Application No: AL/42/21/HH
Site Address: 32 Lime Avenue Westergate Chichester PO20 3UF
Description of works: Erect a fence along the east side boundary

Thank you for your internet representation made on 5th June 2021 which has been recorded as an objection with the comments as follows:

Proposed Fence Line
Marked in Red

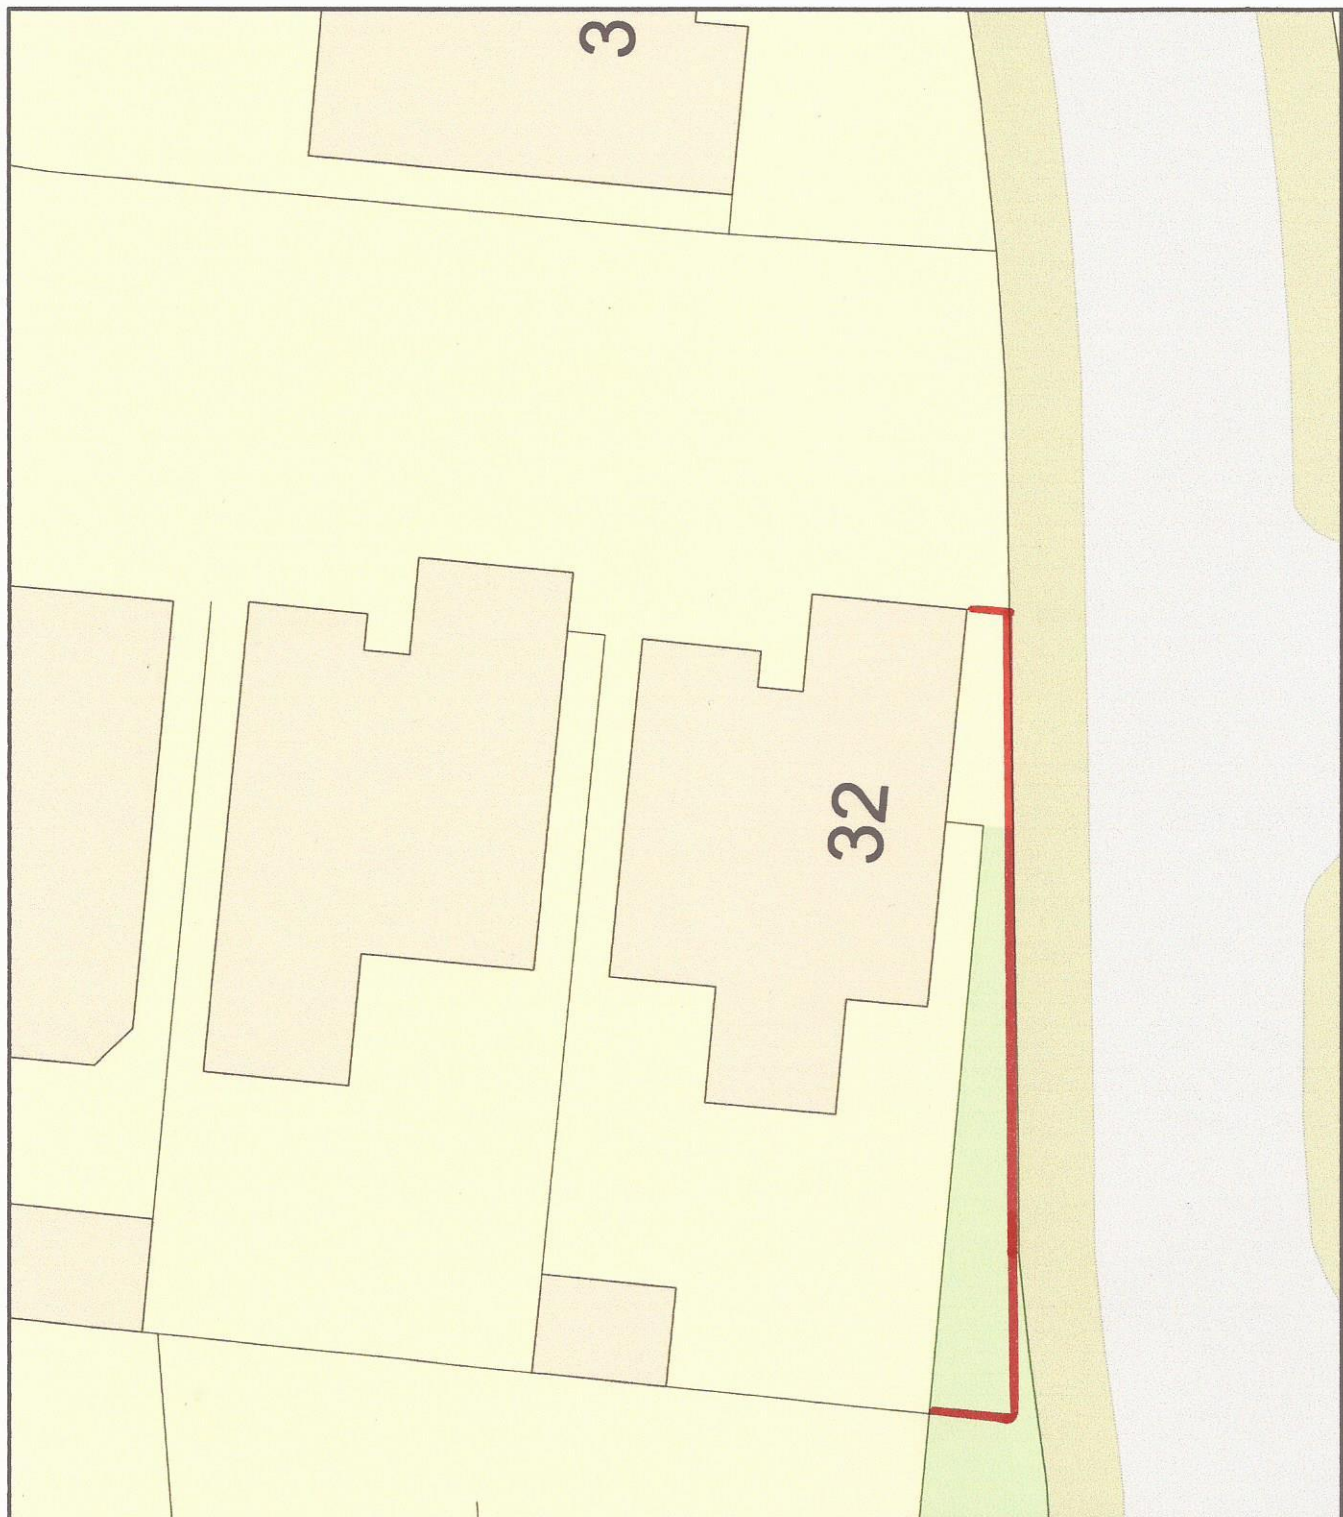
We share the concerns of several close neighbours that the proposed fence will spoil the character of the street creating an overdeveloped appearance by removing open space.

We strongly feel that the fence will create a road safety hazard by restricting visibility down the street particularly for traffic leaving the shared drive serving 32 - 36 Lime Avenue. The road is very busy with cars during school run periods and many children walk past the area to get to the school.

The open space forms part of the approved landscaping plan set out and approved to comply with planning conditions when the houses were built about 20 years ago.
